SITE PLAN APPROVAL
 DISTRICT RAAM USE SFD
 #BEDROOMS 3
9/26/08
 Zoning Administrator

PRELIMINARY
 PLOT PLAN
 FOR
 SHER-LOCK HOMES

RIVERSTONE SUBDIVISION
 LOT 22
 RIVERSTONE DRIVE
 HARNETT COUNTY
 BLACK RIVER TOWNSHIP

PRELIMINARY
PLOT PLAN
FOR
SHER-LOCK HOMES

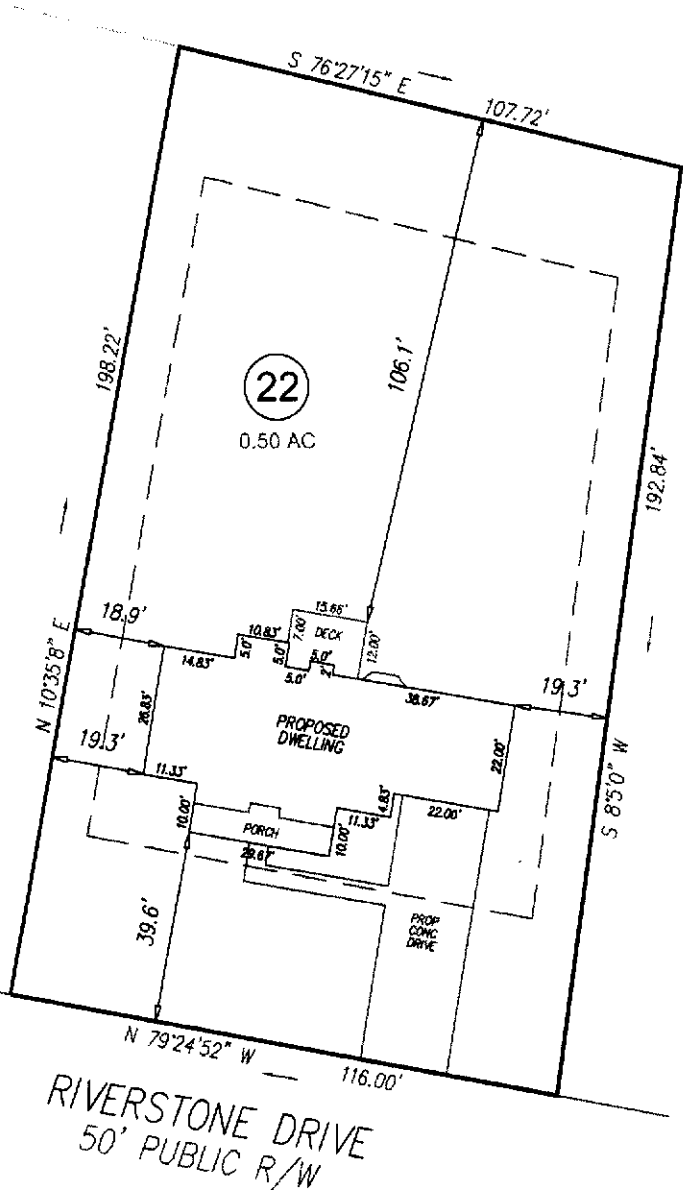
* NEEDS
 CIBLING
 * NEEDS ALL
 IRONS
 * Need report
 on lot

Ex
 Ditched
 on
 property
